From: Ian Wightman [REDACTED]
Sent: 24 July 2015 15:12
To: Simon Davis
Cc: Martyn White
Subject: RE: Planning Consultation on AL/66/15/DOC

## New garage room windows at scale 10:1

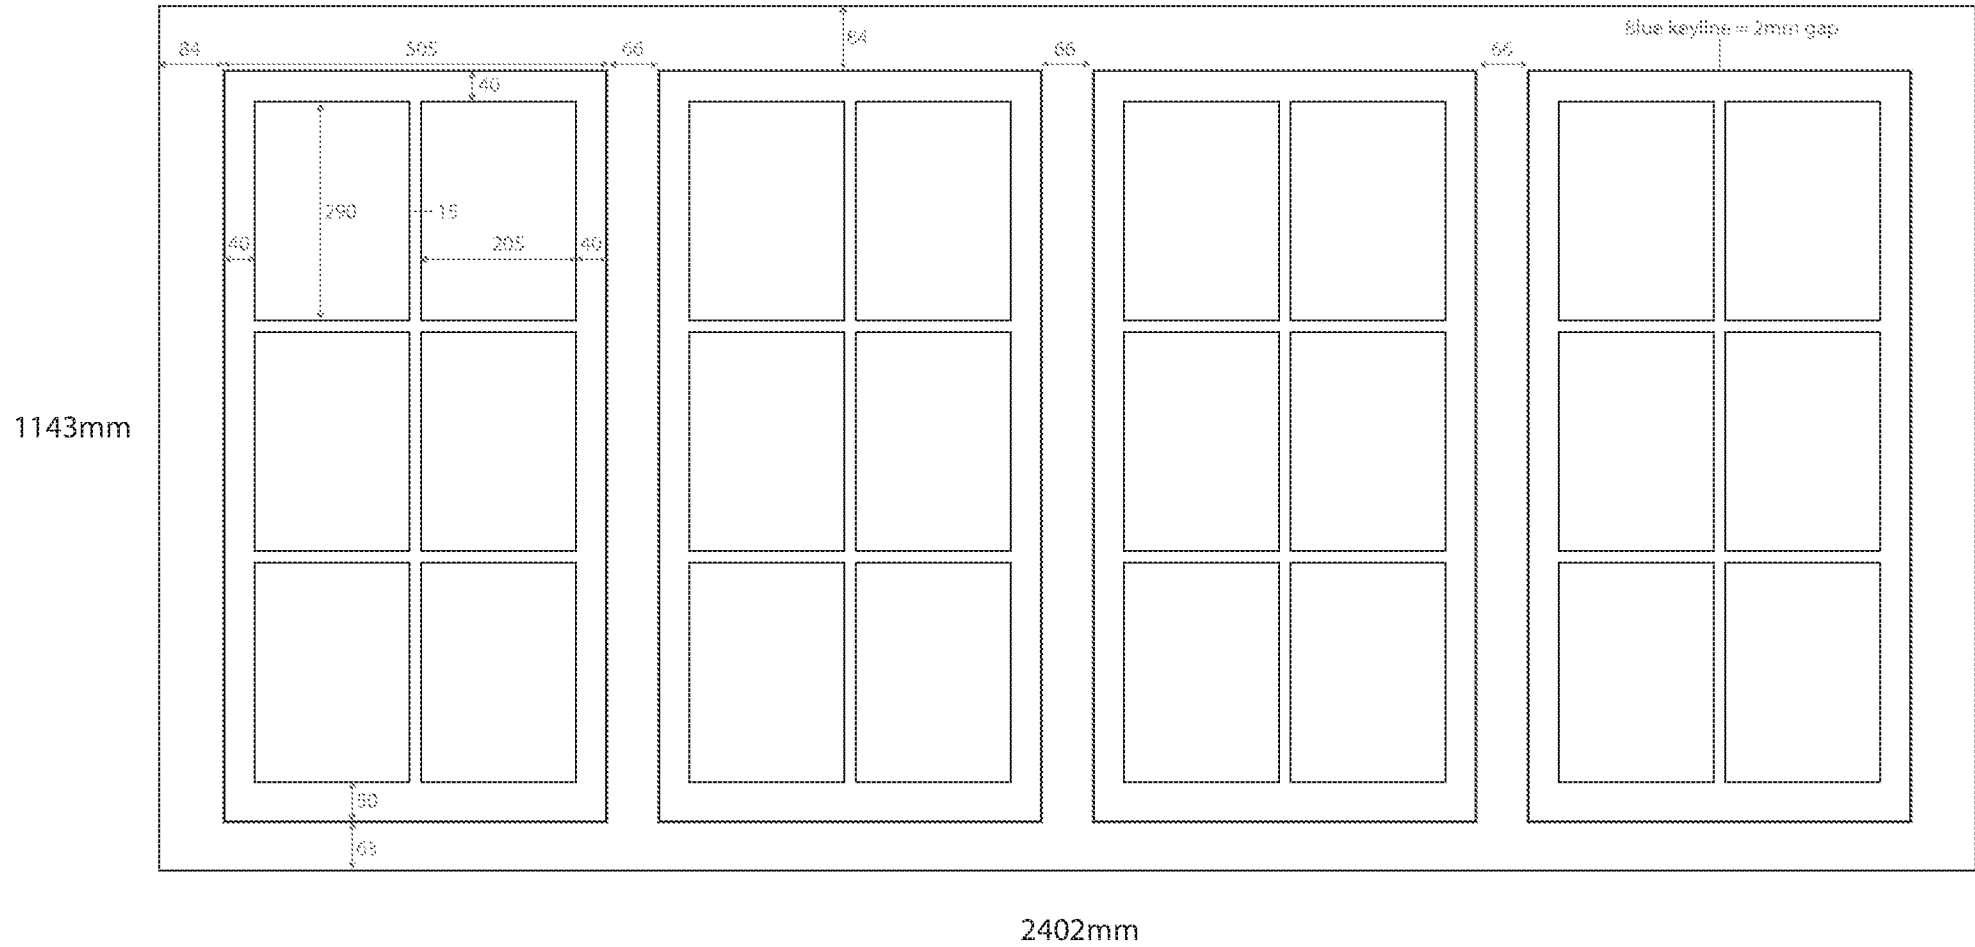
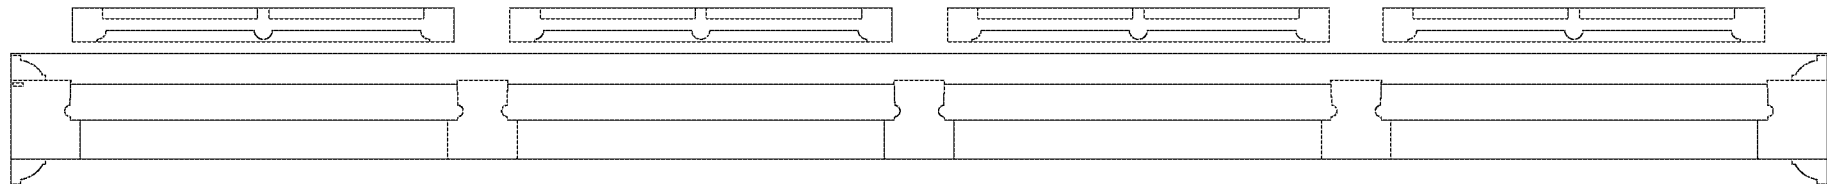
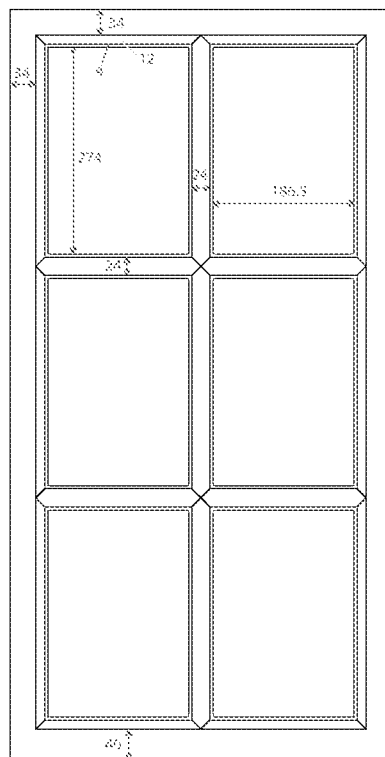
Thank you for the details of the glazing. 14 or 16mm will be fine for the large doors at the rear however the windows should be 11-12mm.
